From: Andrew Wood
Sent: 11 December 2018 10:06
To: Planning.Responses
Subject: FW: FG/172/18/PL - 1ST FLOOR FLAT , Ocean Parade, Ferring
Attachments: 003 Proposed Juliette Balcony 09.12.18.pdf

FG/172/18/PL - 1ST FLOOR FLAT , Ocean Parade, Ferring

PROPOSED ELEVATION SCALE 1:50

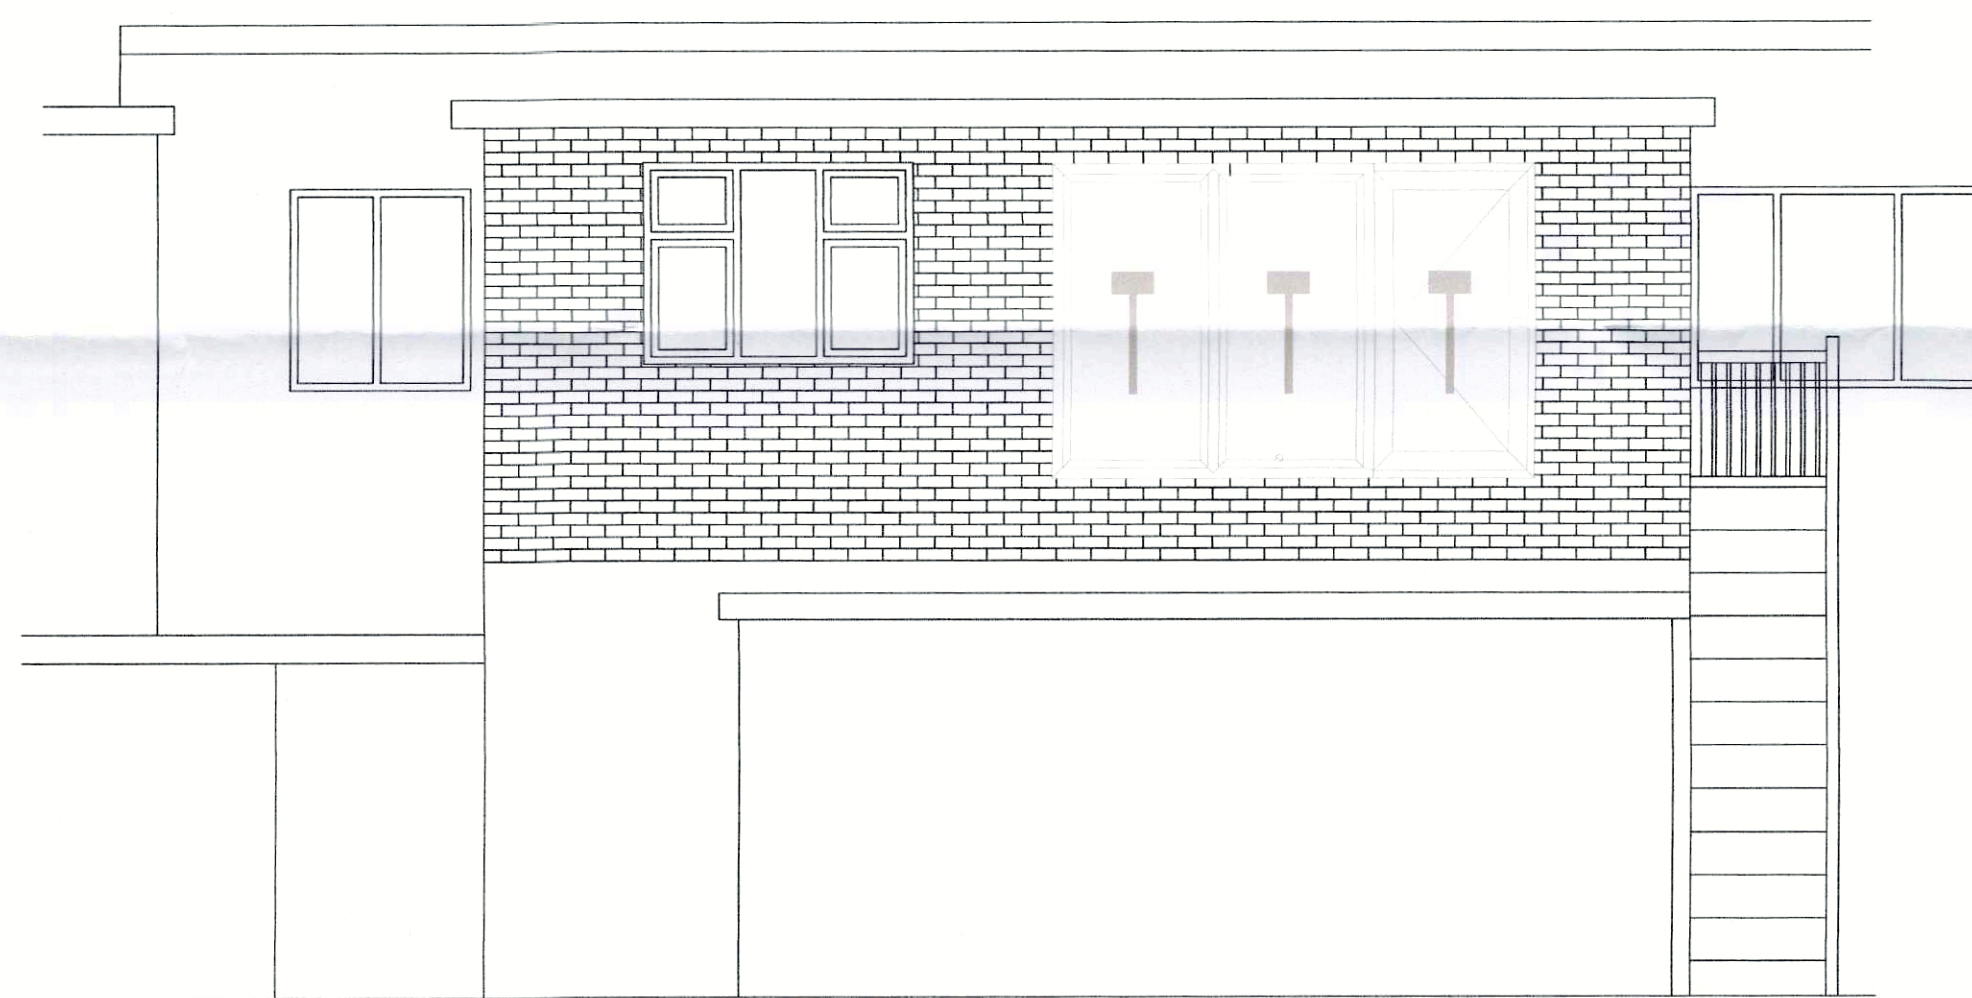
We will however require a plan to scale showing the extent of the glazed balcony for the purposes of making a formal decision on the planning application. Could you forward it to your plan drawer and request he provides us with one.

Could you please provide an additional elevational drawing indicating the juliet balcony and the materials of construction that would sit in front of the Bi Fold doors proposed.
